Your ref
Our ref CPG/EST/3/35/8611
Date: 11 March 2013

**APPLICATION NUMBER 3/2012/1065
CROW WOOD, WARD GREEN LANE, RIBCHESTER
GRID REFERENCE SD 628 372**

Drawing No.
TR/JP/3520

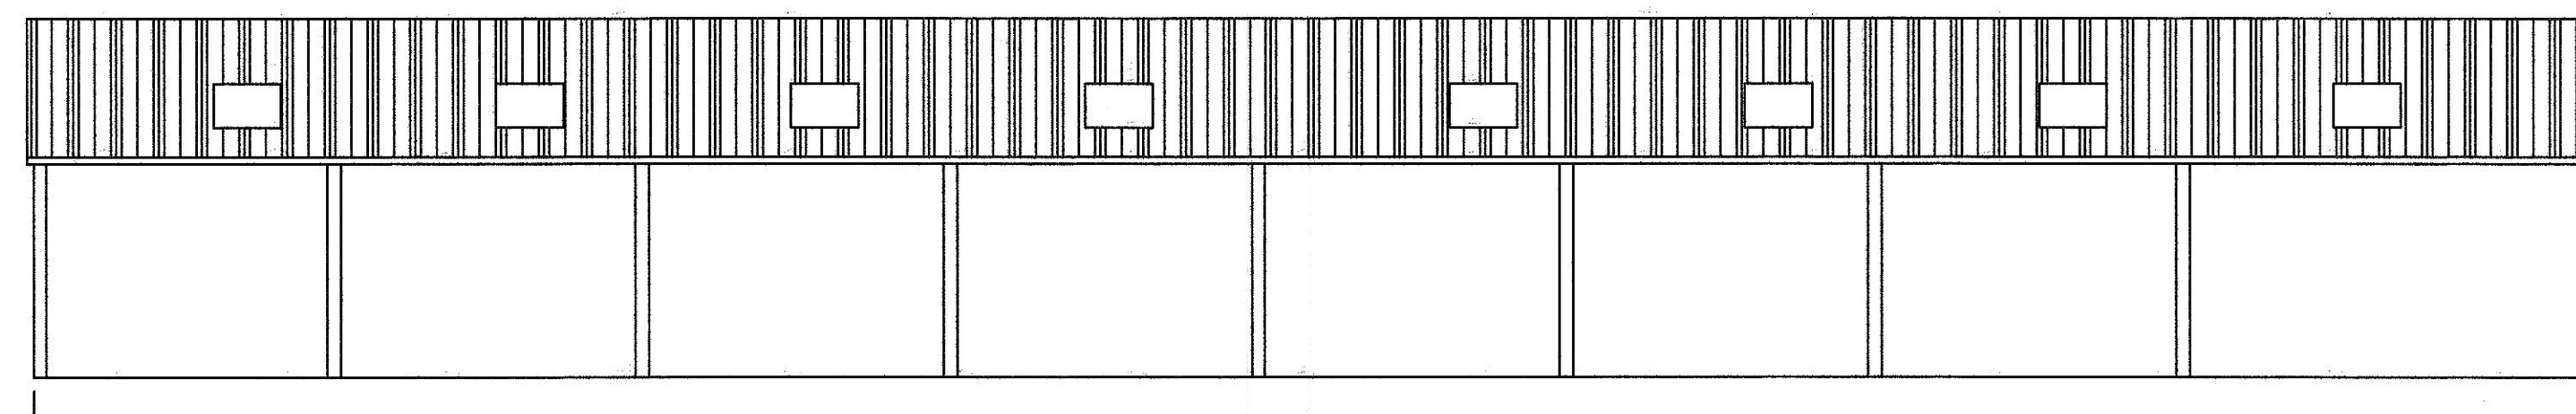
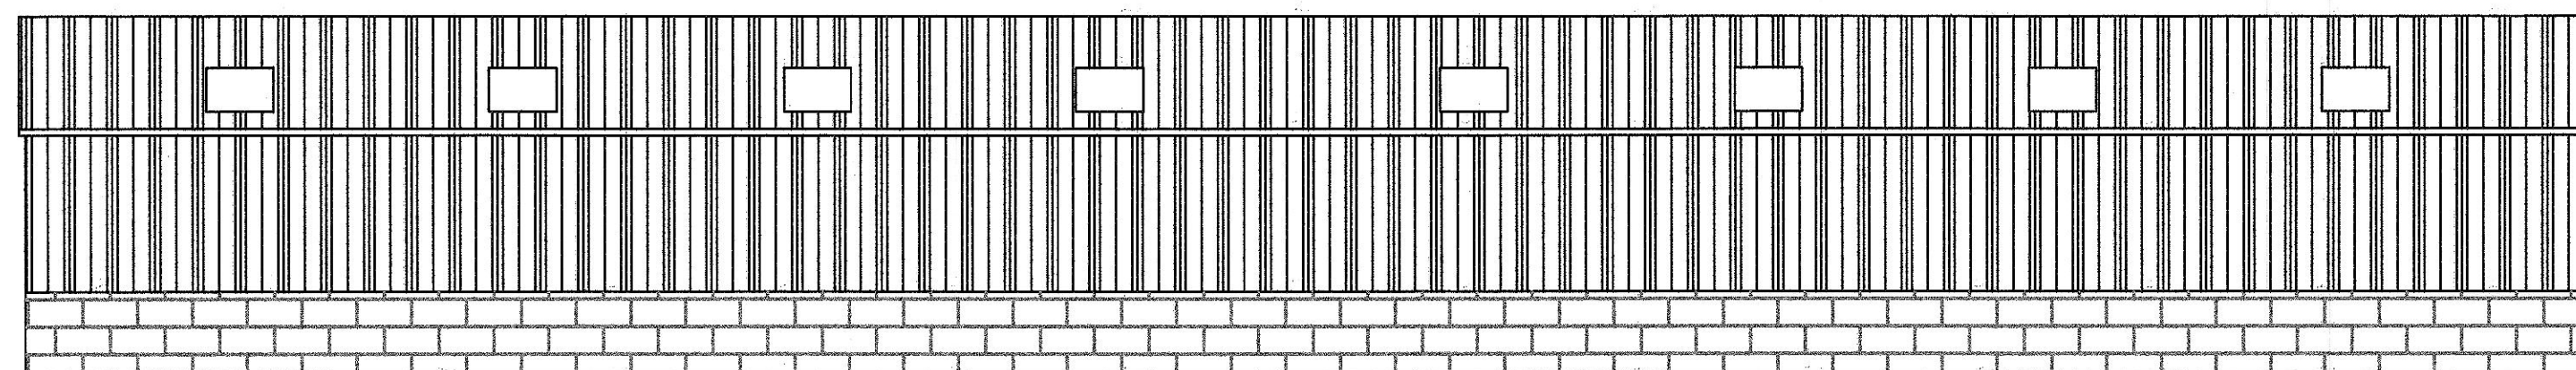
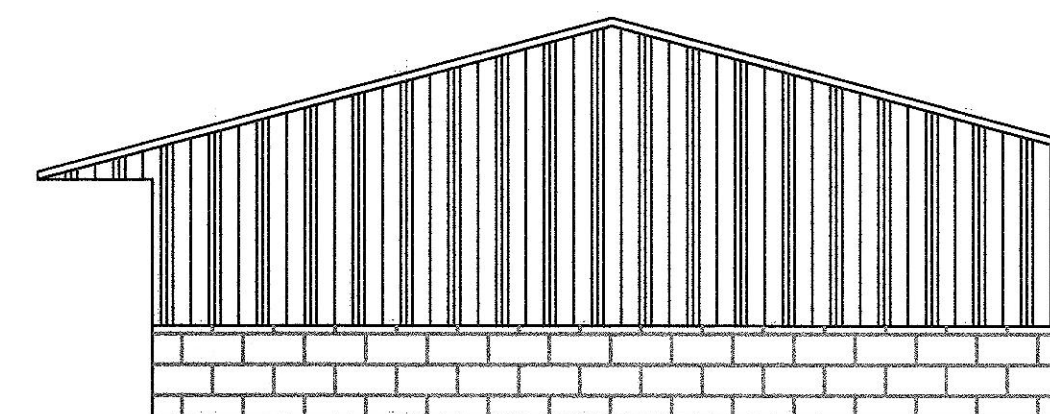
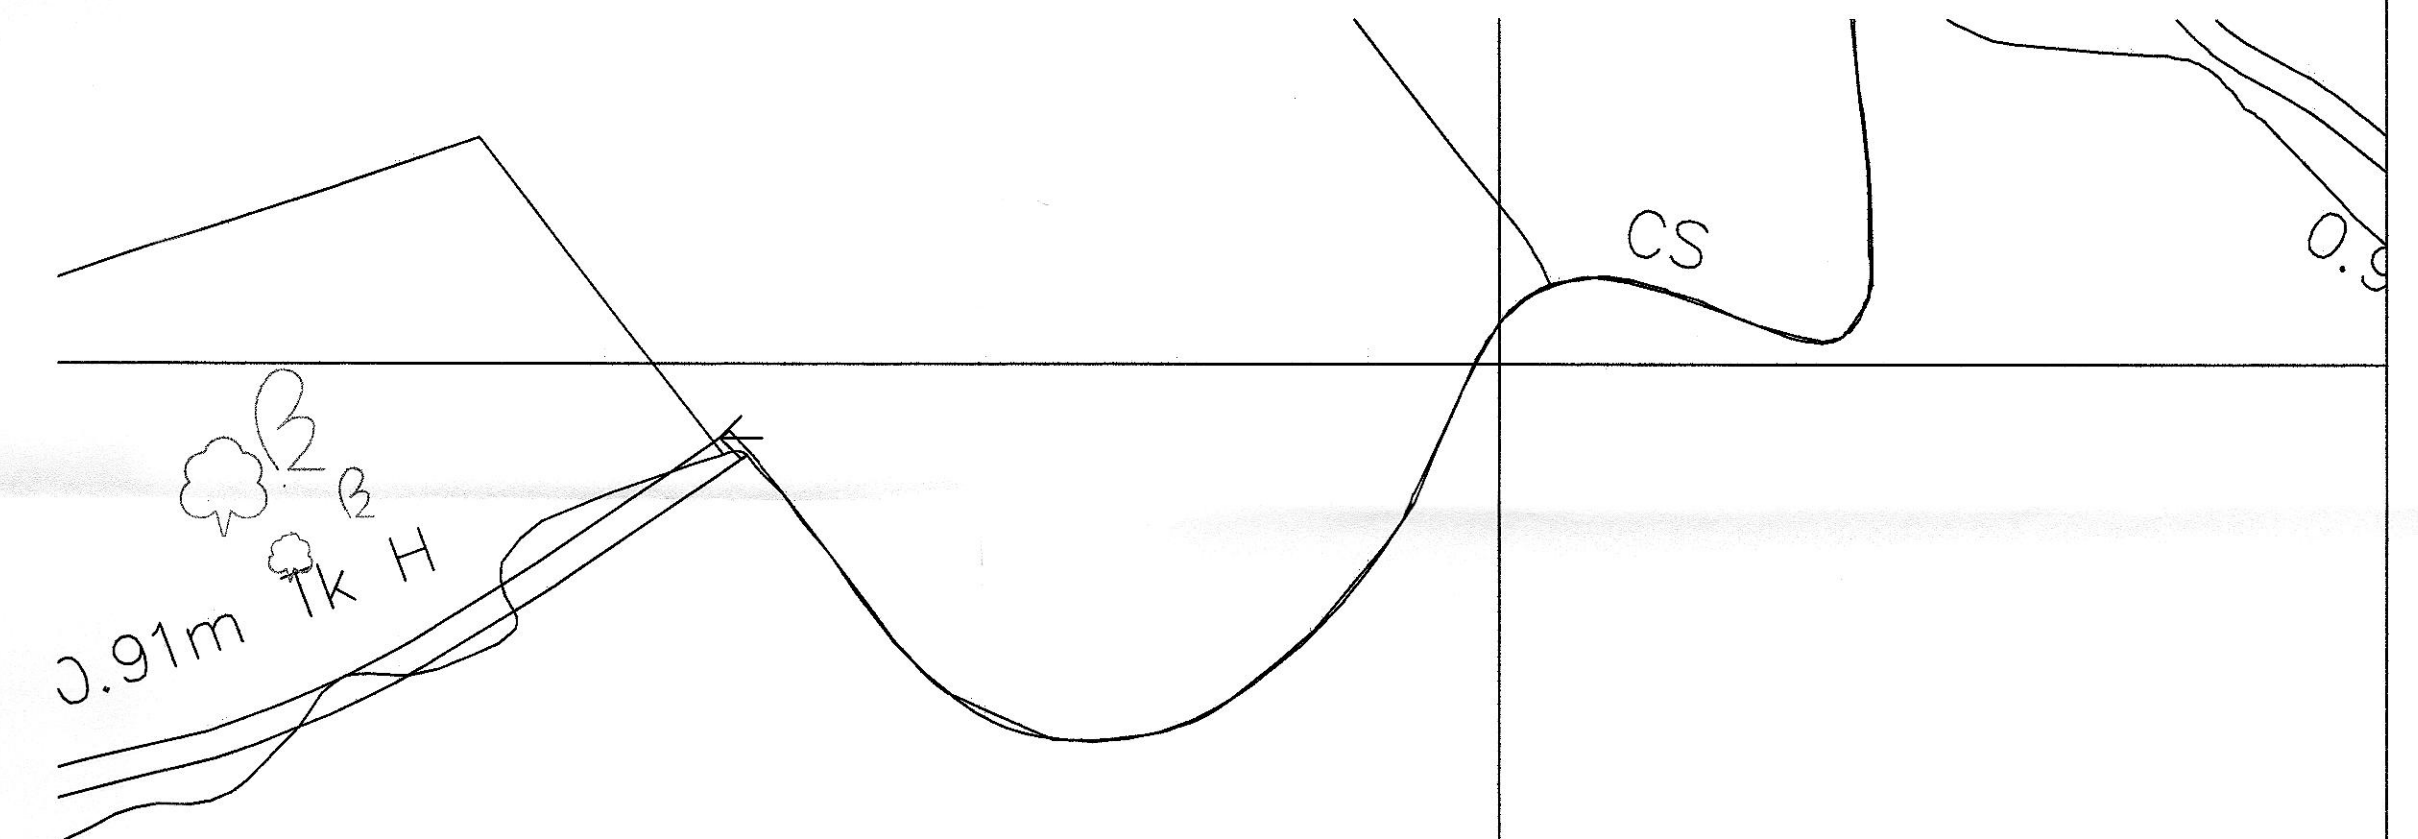
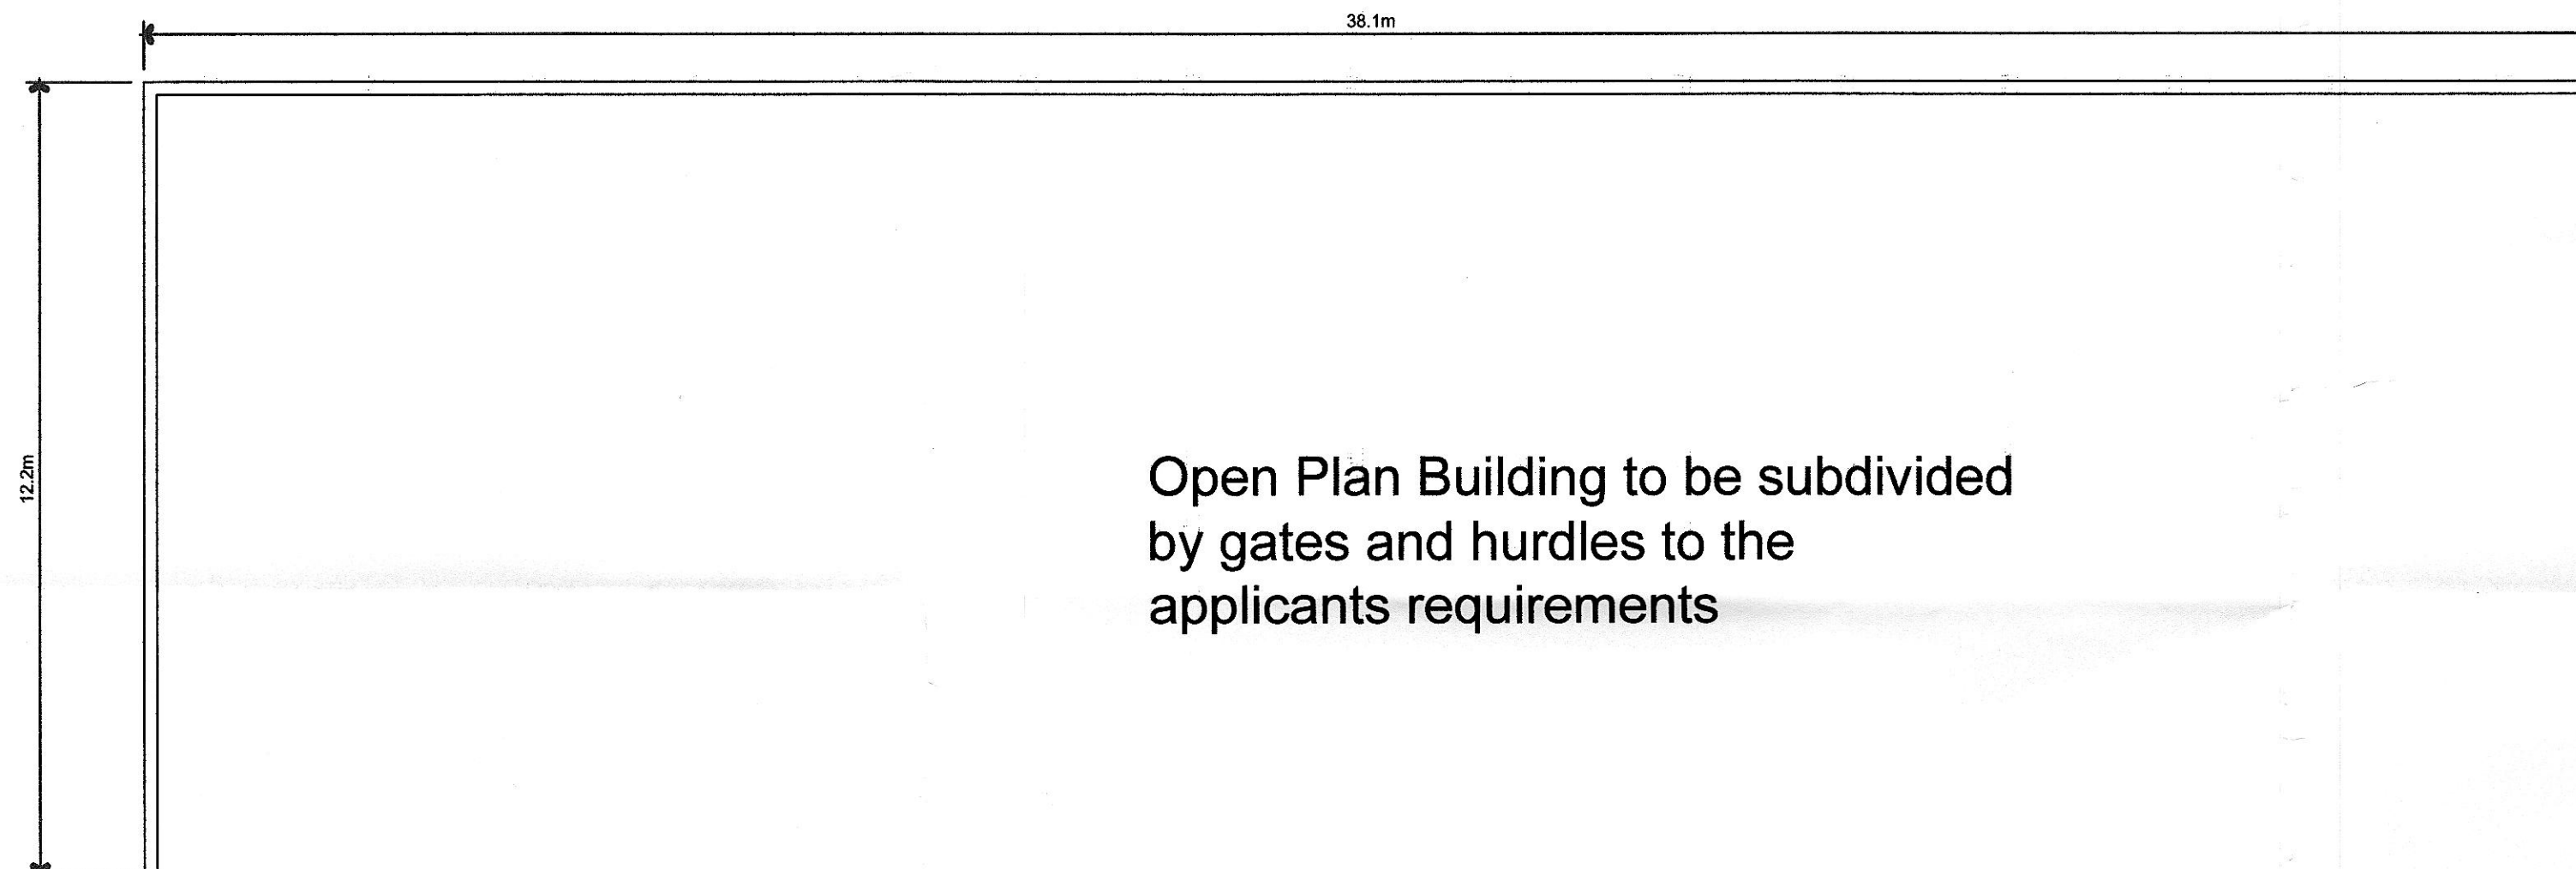
It is proposed to erect an eight bay steel portal framed building measuring approximately 38.1m x 12.2m with an eaves height of 3.65m. The building would be open fronted and have concrete panelled or block walls with metal sheeting above. Details of the proposed building are shown on drawing number TR/JP/3520 shown on the application site. Mr Robinson explained that the building would be used for lambing purposes, and also for general storage purposes.

The design of the building is of a typical agricultural construction and uses materials appropriate for the intended use. The building is proposed to be open fronted which allows easy access in and out of the building and also facilitates management. I therefore consider the design to be acceptable.

Scale 1:500

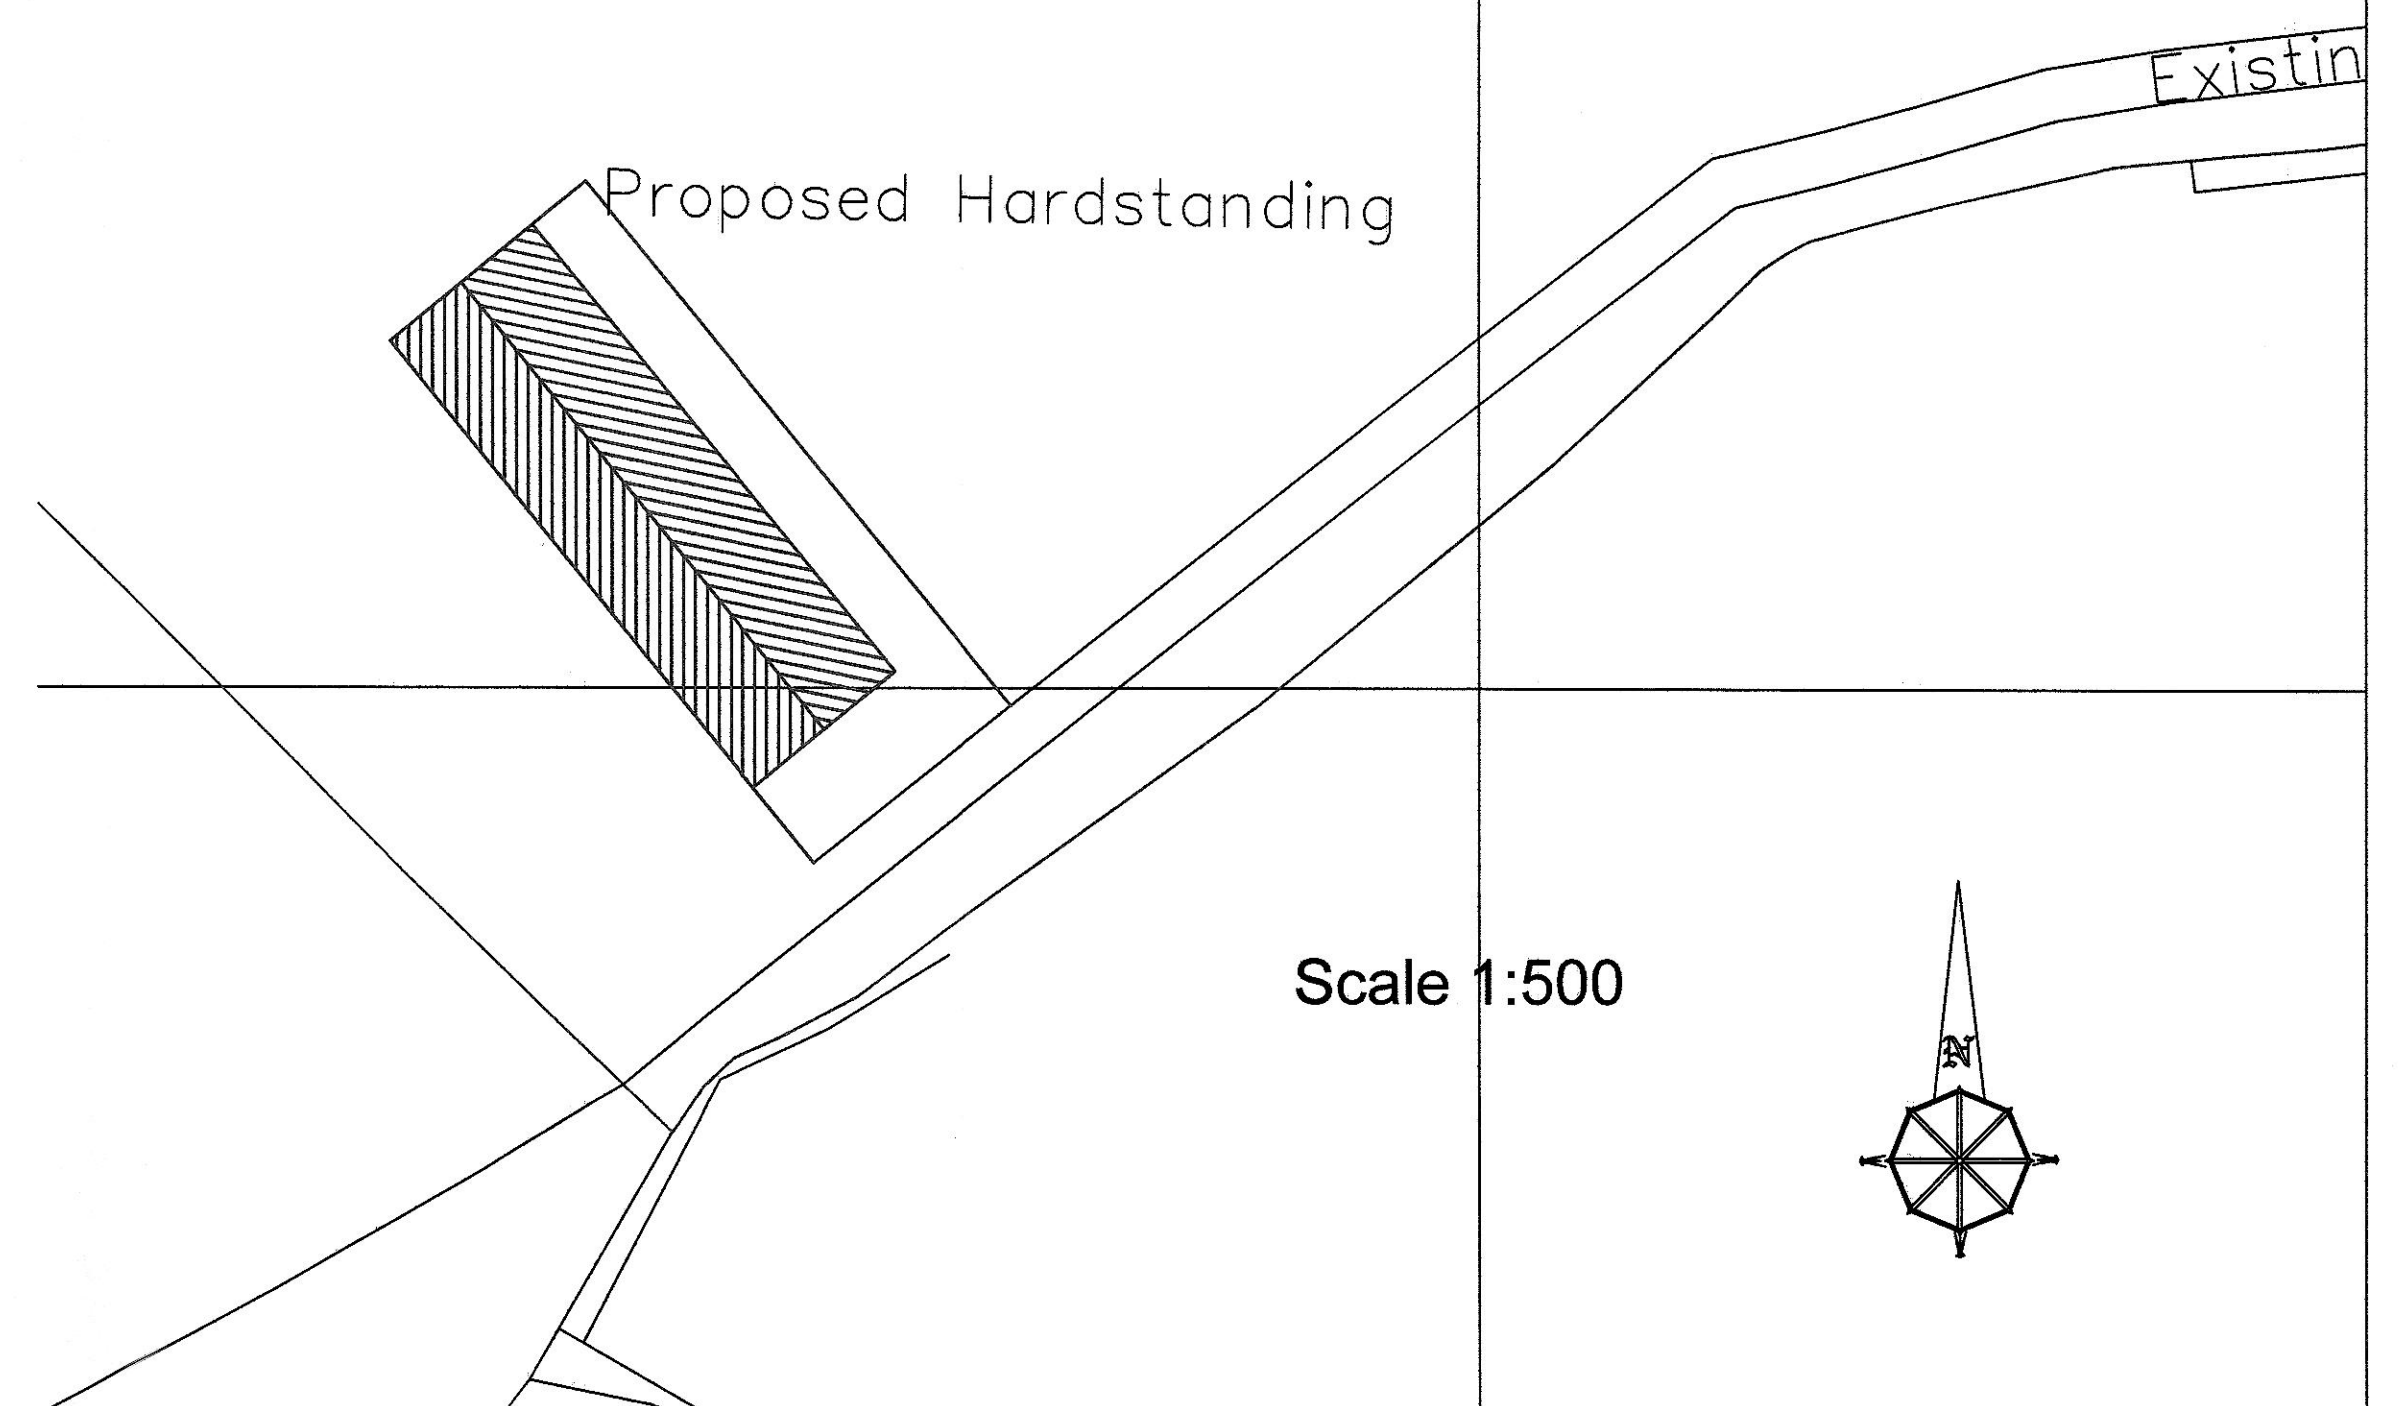
In relation to the proposed siting at the intended location, as there are no other buildings on the site, in my opinion, wider planning policies such as those in relation to visual impact will be the determining factor in terms of siting. I would however comment that the proposed site is some distance from the highway. I understand that the reason for this relates to the fact the applicant considers that a site closer to the highway is not possible due to topography. No doubt you will have your own opinion regarding this, however, in my opinion a site closer to the road may be possible. A site closer to the road would also avoid the need for extending the access track.
